City of Albuquerque Stormwater Construction Site Inspection Report

ESC File No.	K15E005G	Project Name:	PHS SE Parking Garage		
NPDES Id. No.	NM1002V2	Location:	1300 Central Ave. SE		
4/27/2021	Owner	Contractor			
Operator	Presbyterian Healthcare Services		Enterprise Builders		
Contact name & title	Jim Jeppson		Mike Bertitto		
e-mail	JJeppson@phs.org		mikebertitto@ebnm.com		
Contact Phone #	505-841-1769		505-264-3961		
COA Inspector	Thomas Evans		Start/End Time:	3:20 PM/4:15 PM	
Construction Phase:	Vertical				
Type of Inspection:	<input checked="" type="checkbox"/> Regular	<input type="checkbox"/> Storm Event	<input type="checkbox"/> Past Storm Event >0.25"	<input type="checkbox"/> 311/Complaint <input type="checkbox"/> Follow Up	
Weather at time of inspection?	cloudy		Temperature: ~	62	
Estimated date of last storm 0.25" or greater	4/28/2021

**C-150**  
OF

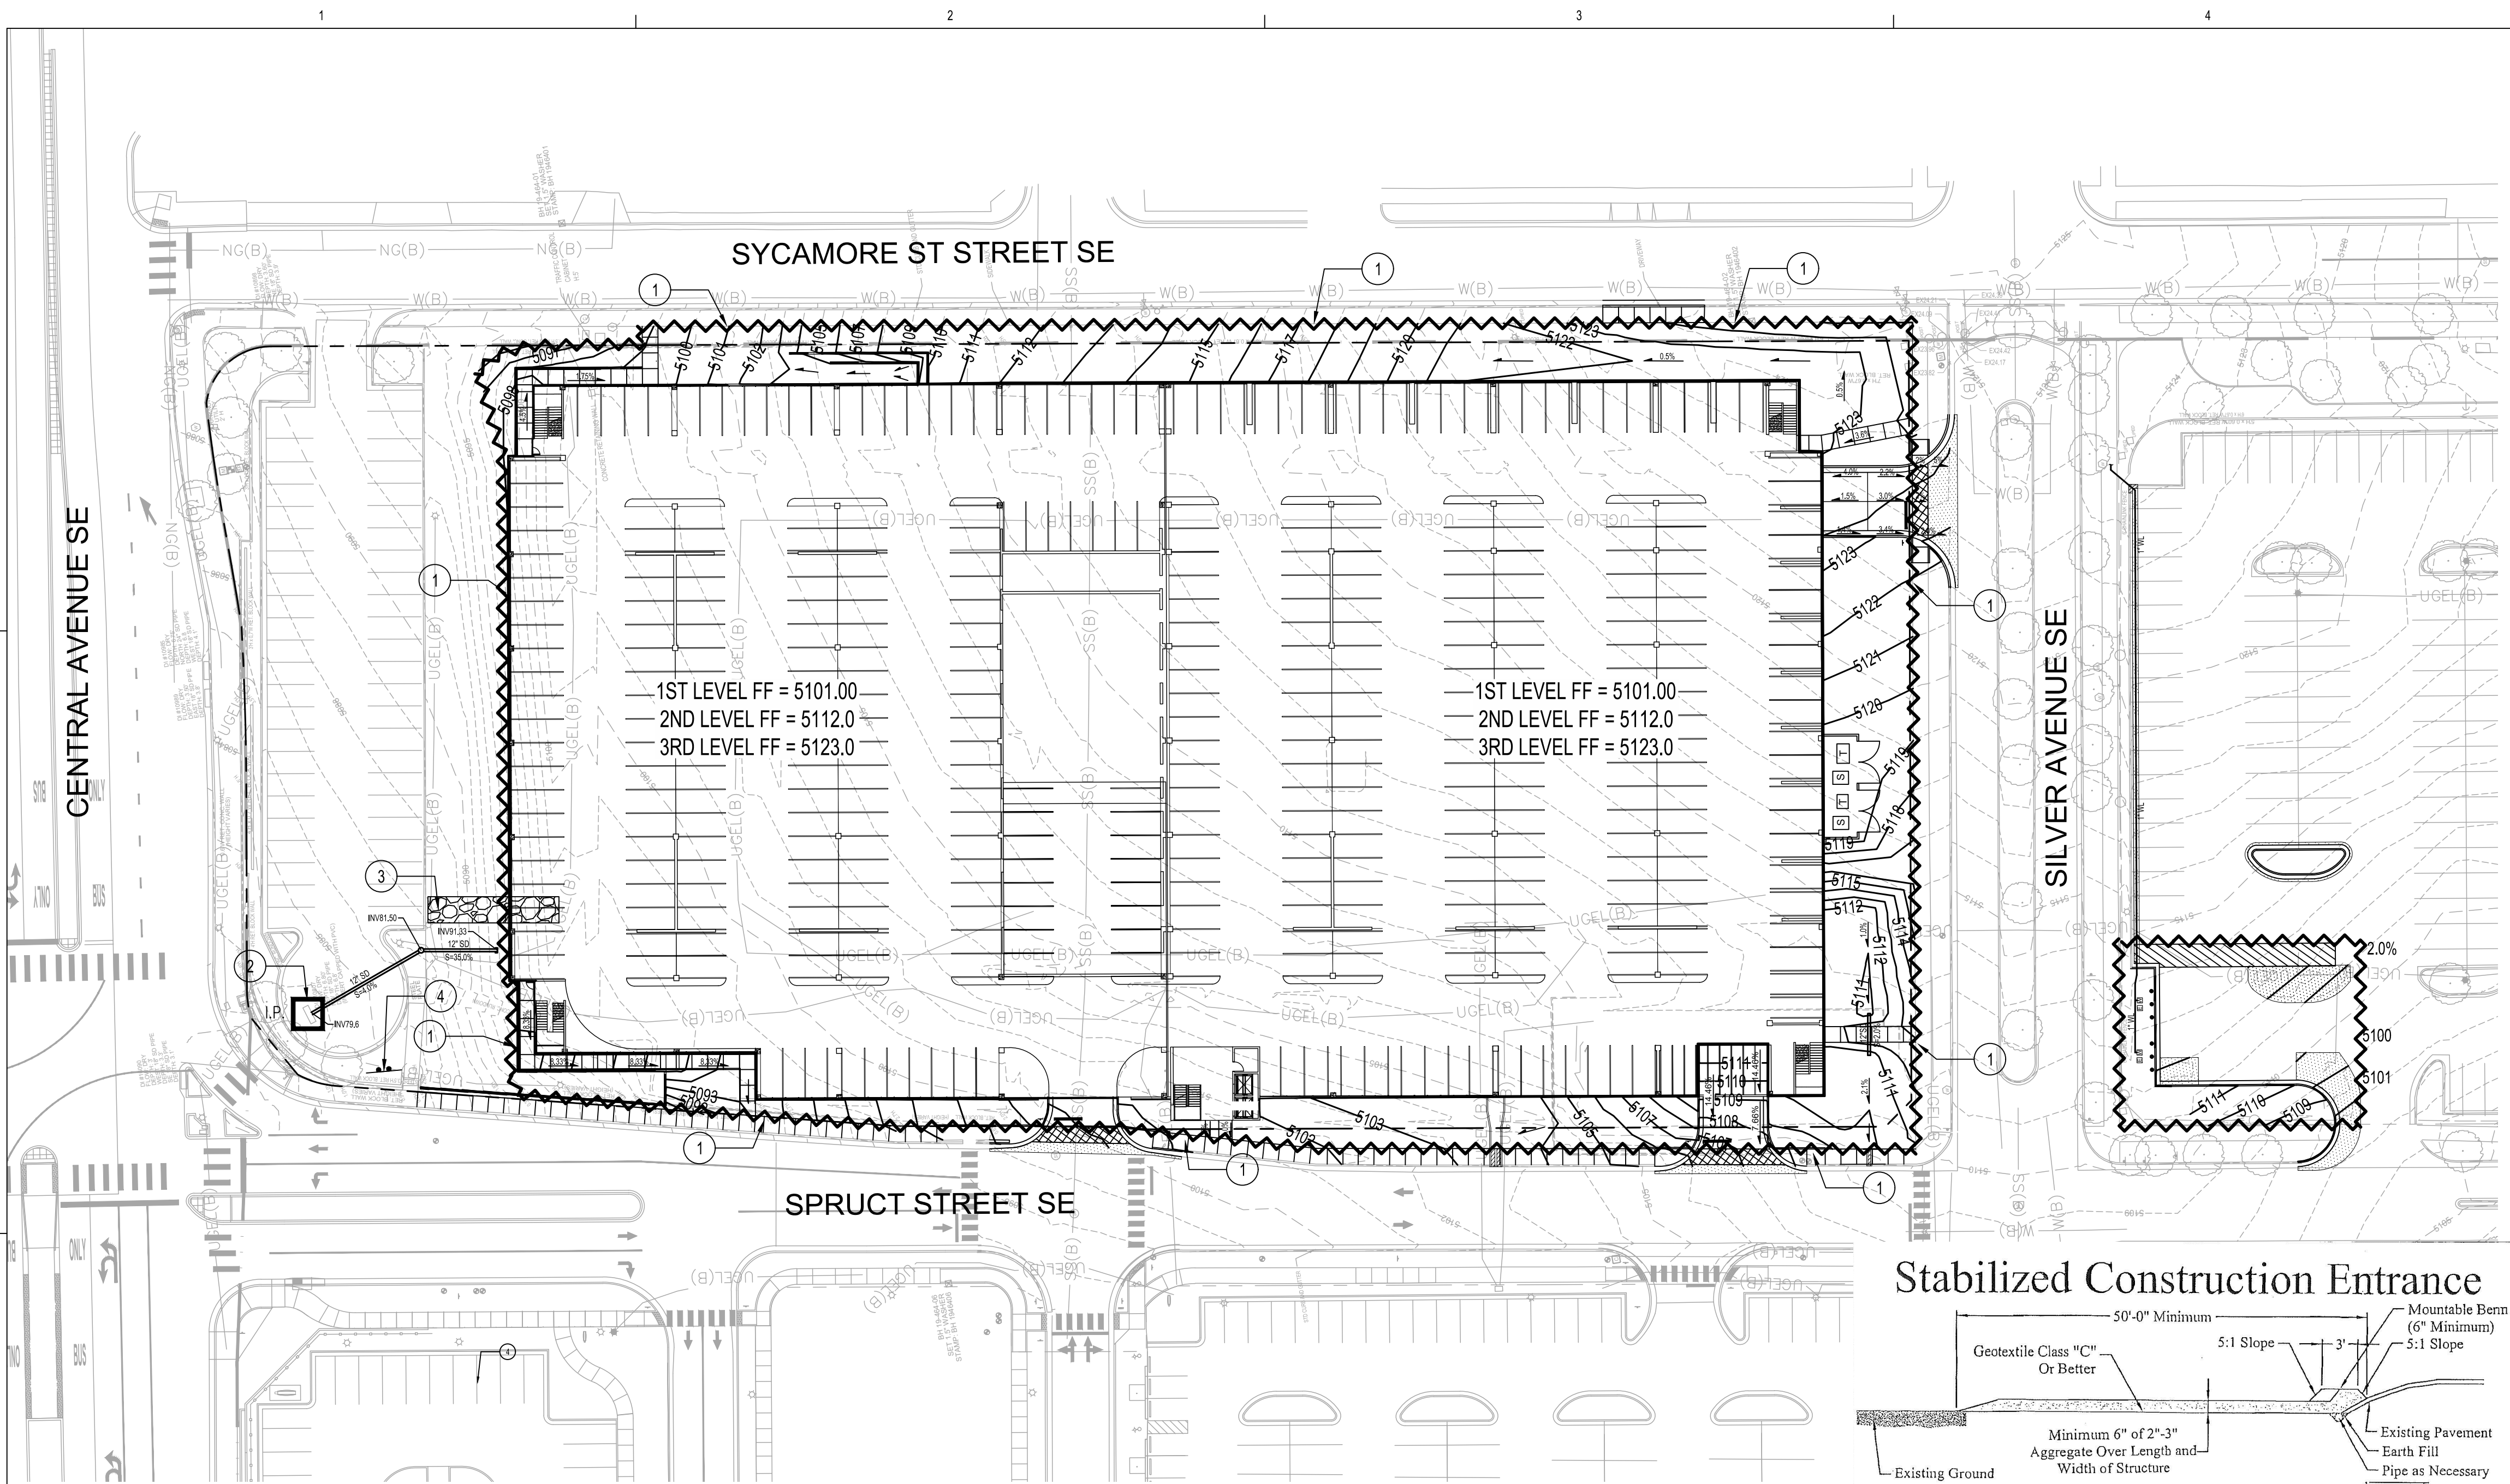
Item Number	Deficiency/ Corrective Action				
1	Wattles were not covering the length of the fence in some areas. Reposition wattles to prevent any discharge of sediment.				
2	Waste/debris accumulation in the SW corner of the site where the wattle is not properly positioned. Clean the area and reposition wattle.				
3					
4					
5
